Comment for planning application 20/00841/F

| Location | <input type="text" value="Barn And Land South West Of Cotefield Farm Church Street Bodicote"/> |
| Proposal | <input type="text" value="Erection of garage adjacent to approved dwelling and change of use of agricultural land to residential use"/> |
| Type of Comment | <input type="text" value="Objection"/> |

Proposed Ground Floor Plan

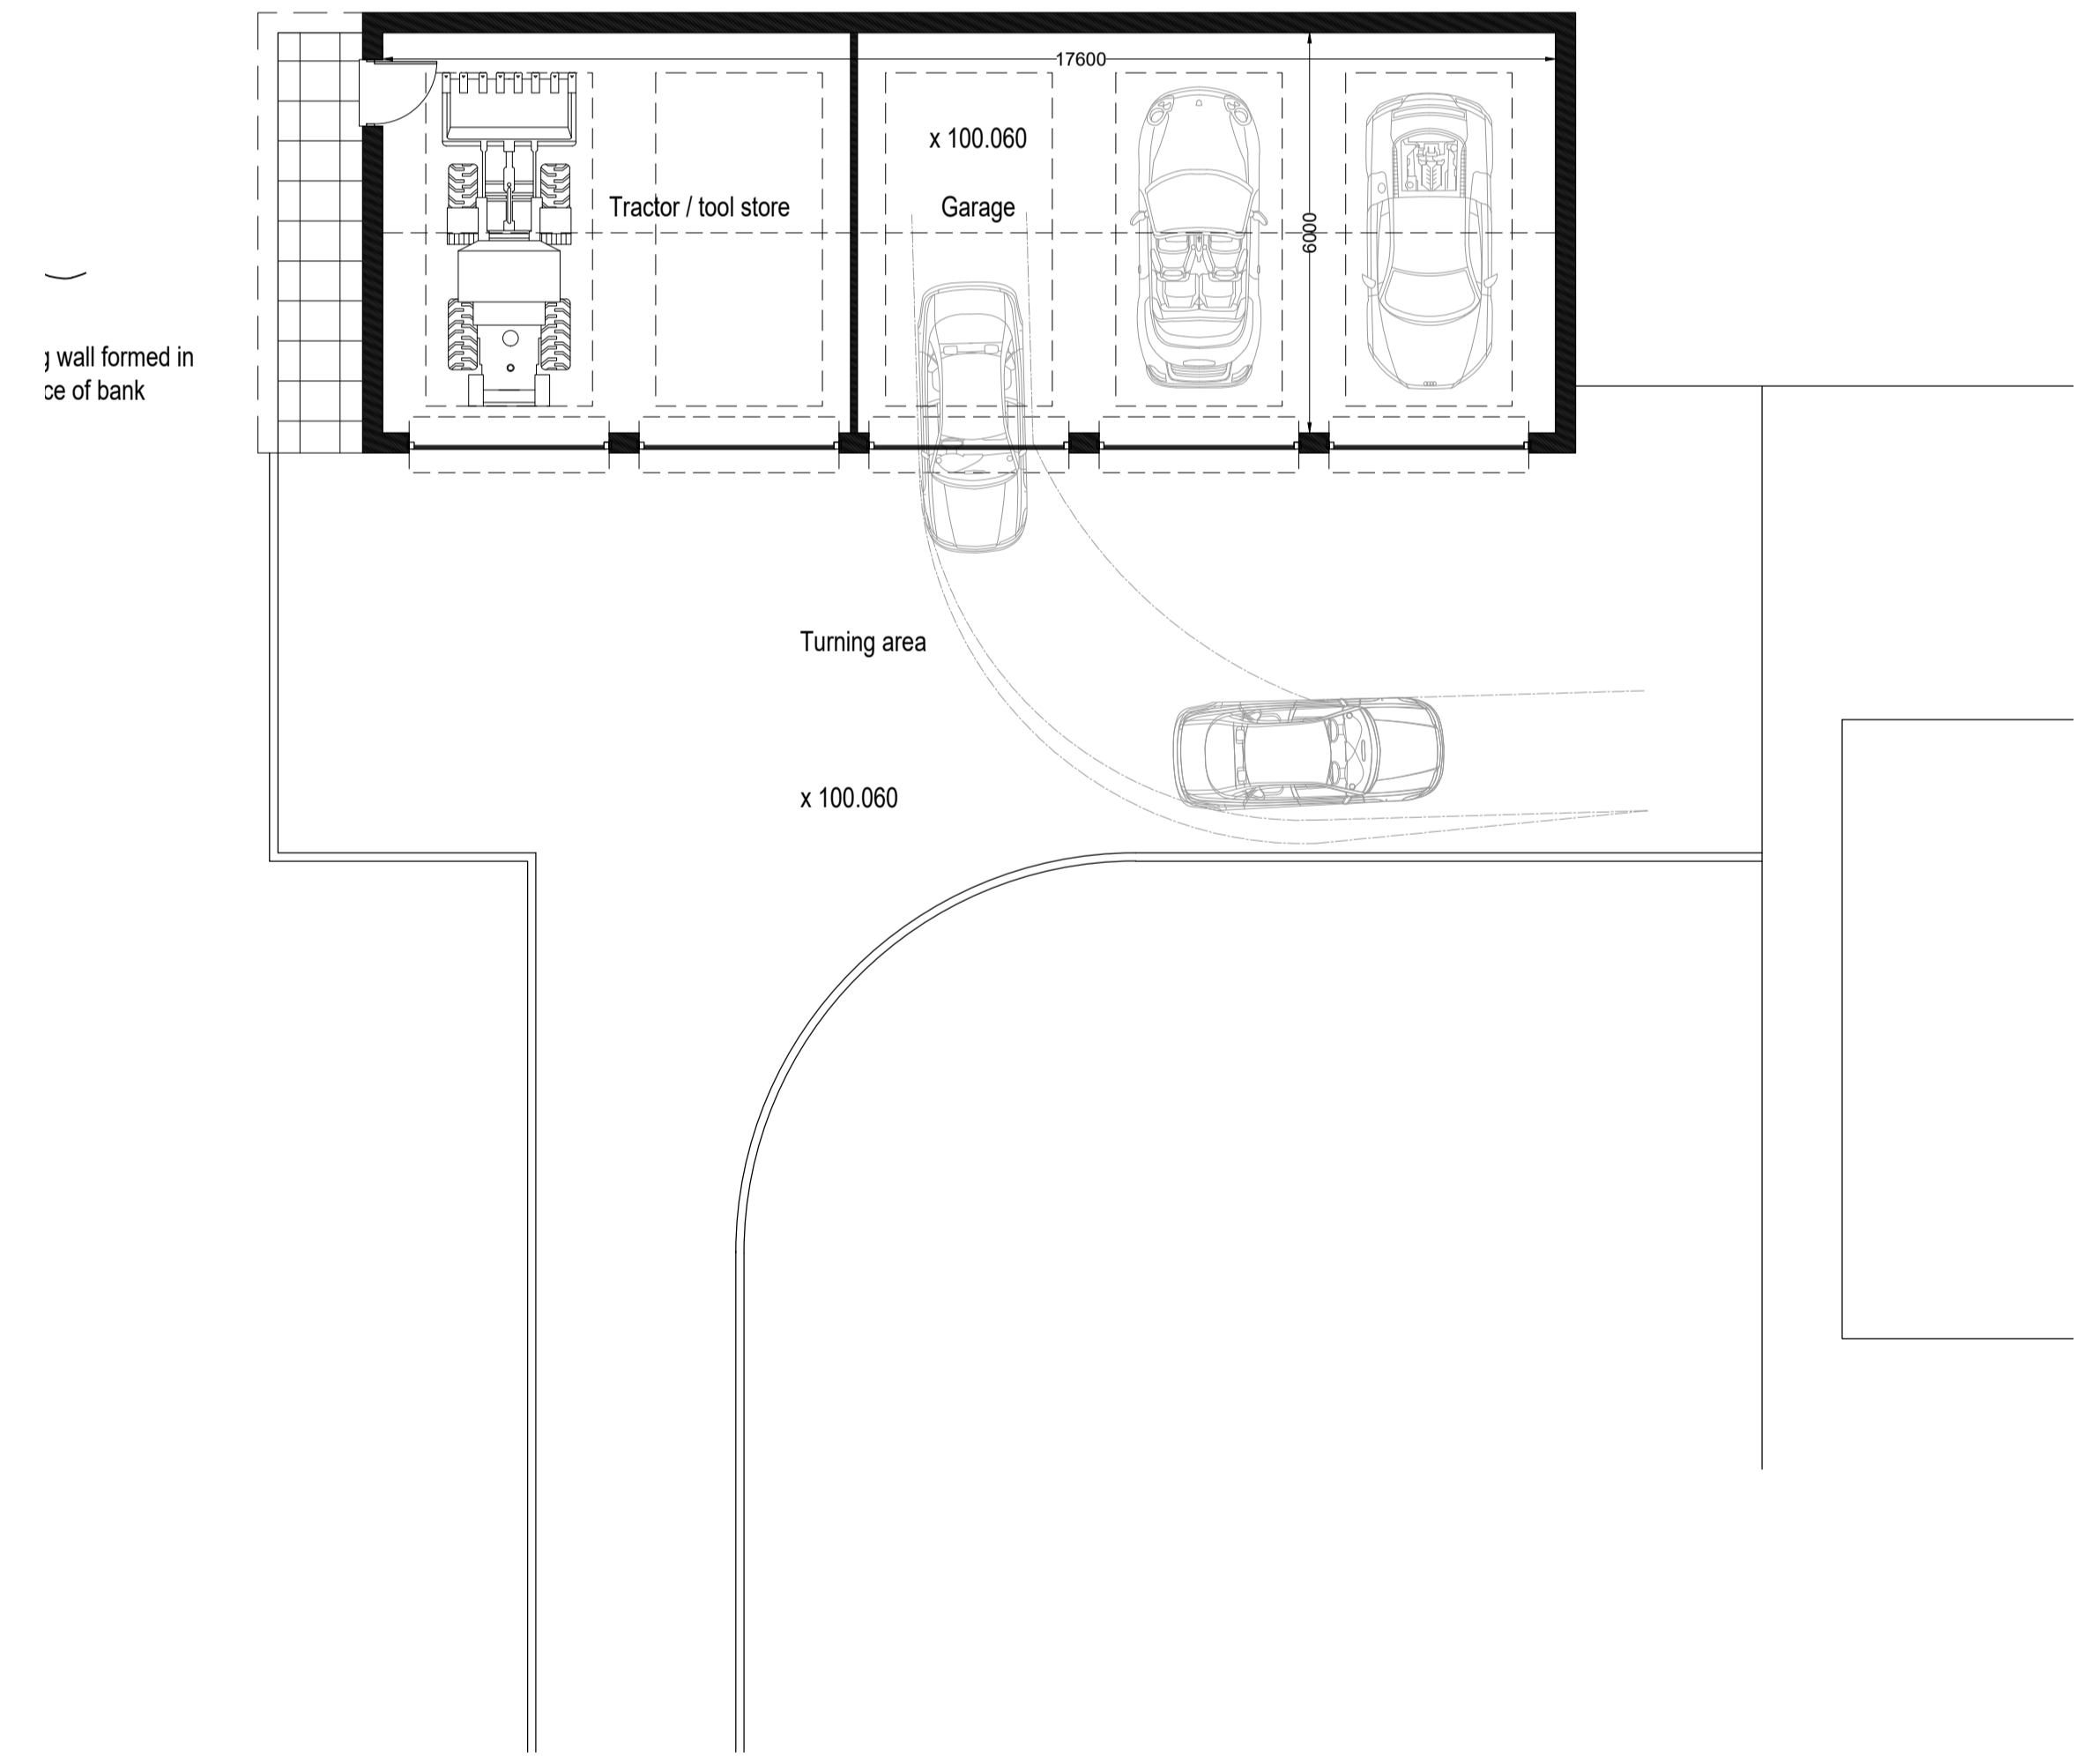
| Comments | <input type="text" value="Buildings are not in keeping with the rural landscape and, without substantial screen planting, they will be highly visible from the village and footpaths. The size, siting and design of the 5 garages are considered an unnecessary and excessive development for a residential property even allowing for the storage of grounds maintenance equipment. We believe this development would cause an unjustified visual intrusion into the valued rural landscape and open countryside. We understand this application is contrary to the provisions and aims of saved Policy C28 of the CLP 1996, Policies ESD 10, ESD 13 and ESD 15 of the CLP 2031 and Government guidance within the NPPF in respect of conserving and enhancing the natural environment."/> |
